Addendum No. 1

RE: Contract # C204861

Lenoir County (B-4926)

BRIDGE #530020 OVER NEUSE RIVER AND BRIDGE #530034 OVER NEUSE RIVER OVERFLOW ON NC-55

PHASING

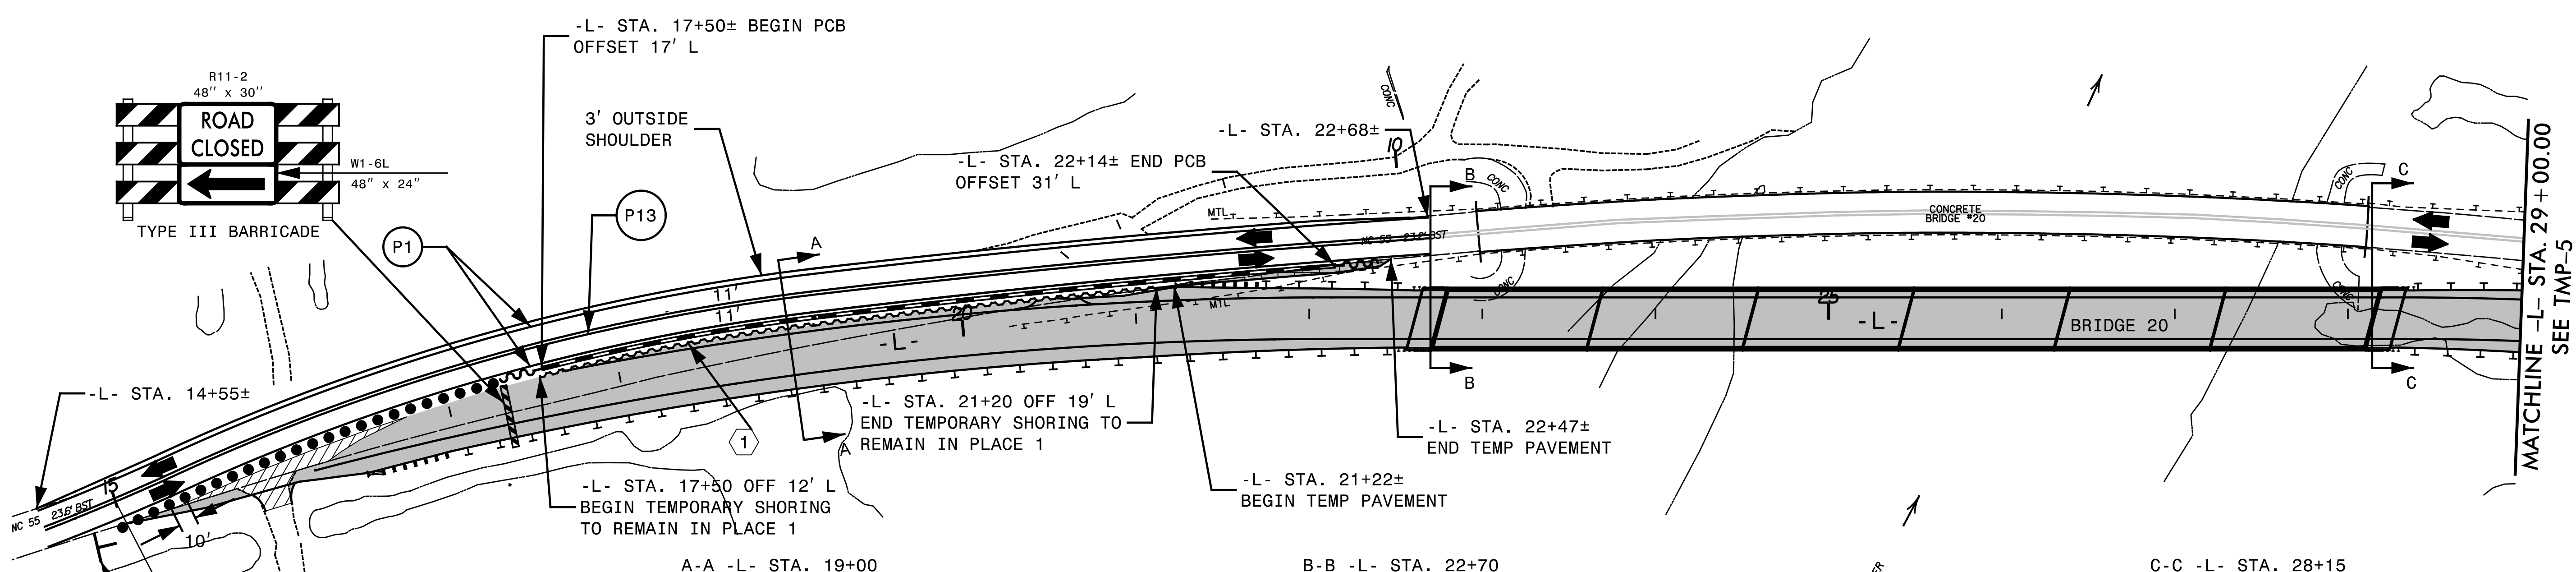
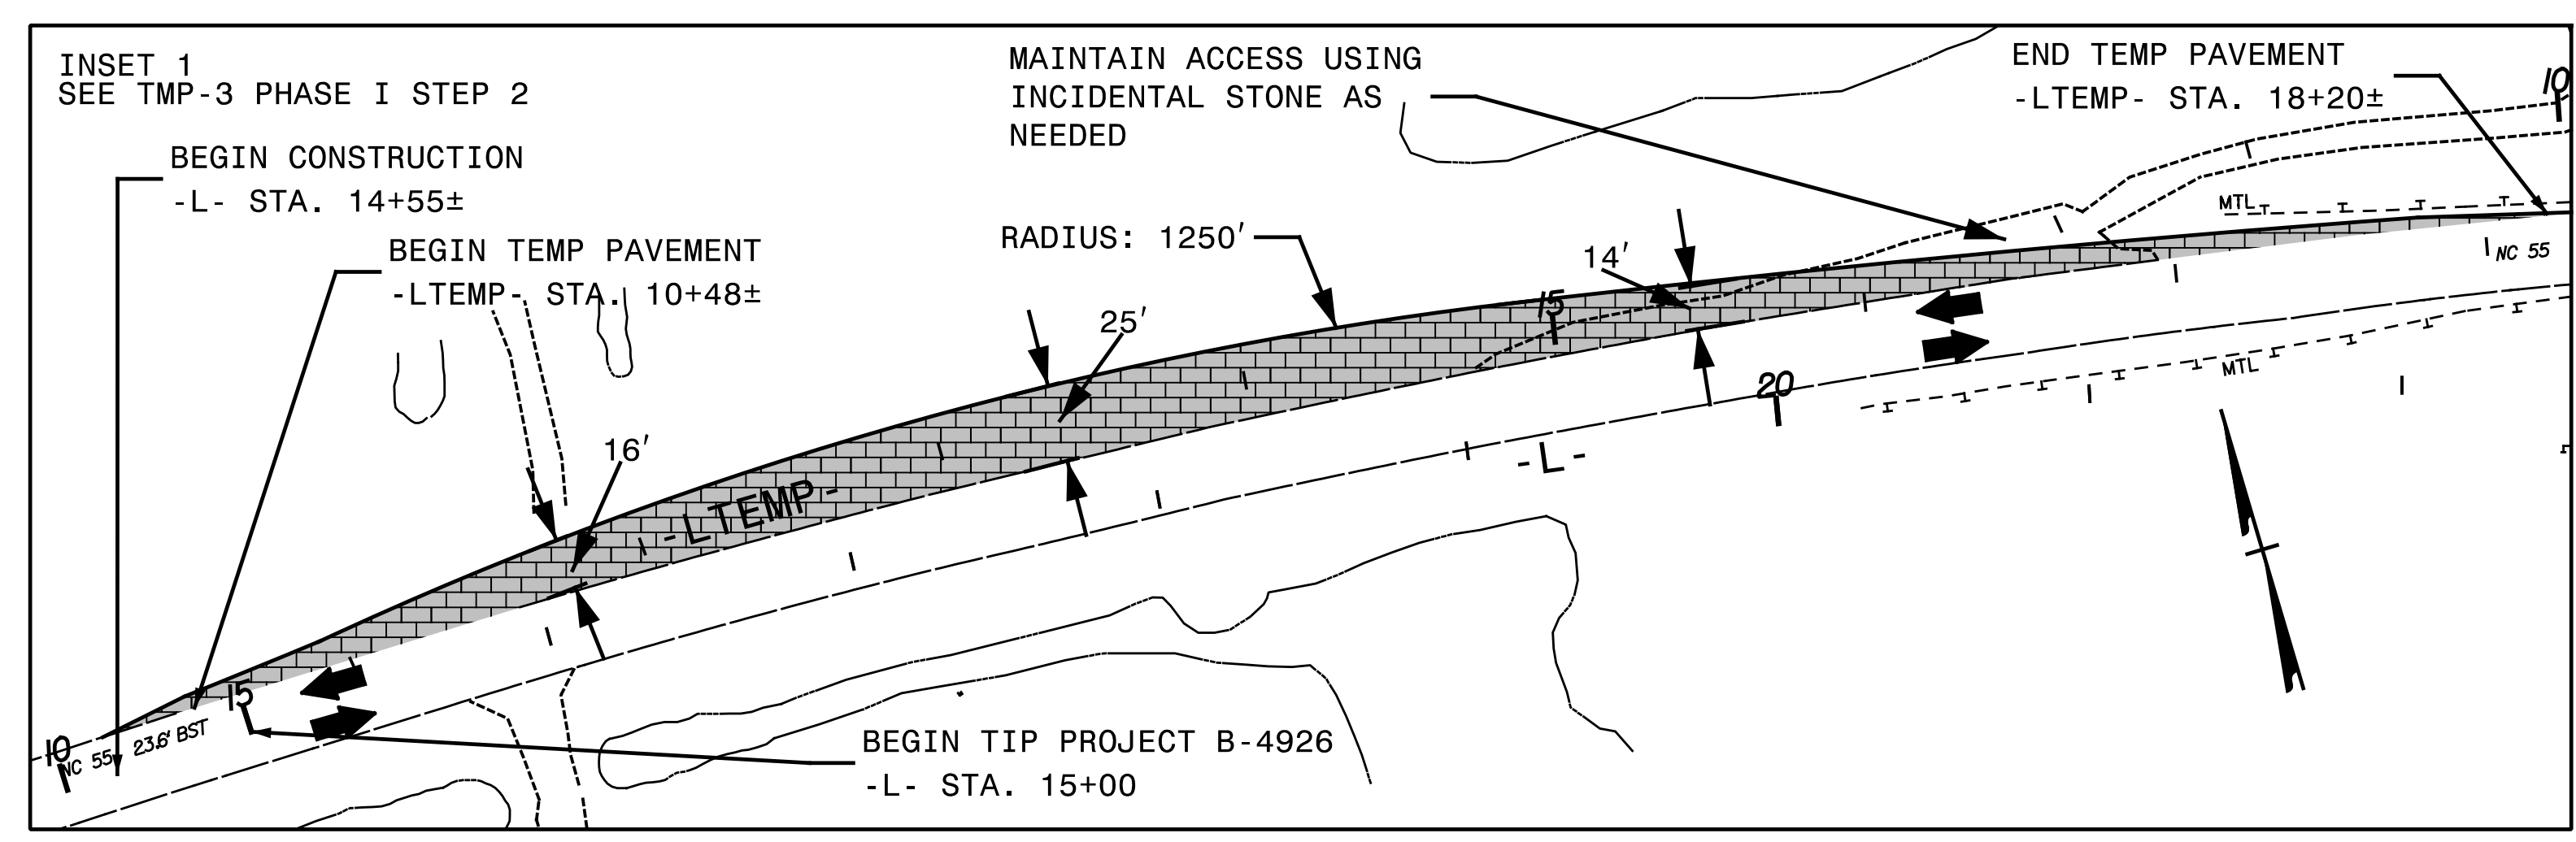
1) Portions of the temporary shoring on the project shall not be removed as noted in the plans. No separate payment will be made for leaving temporary shoring in place. The cost for leaving temporary shoring in place will be included in the contract unit price for *Temporary Shoring*.
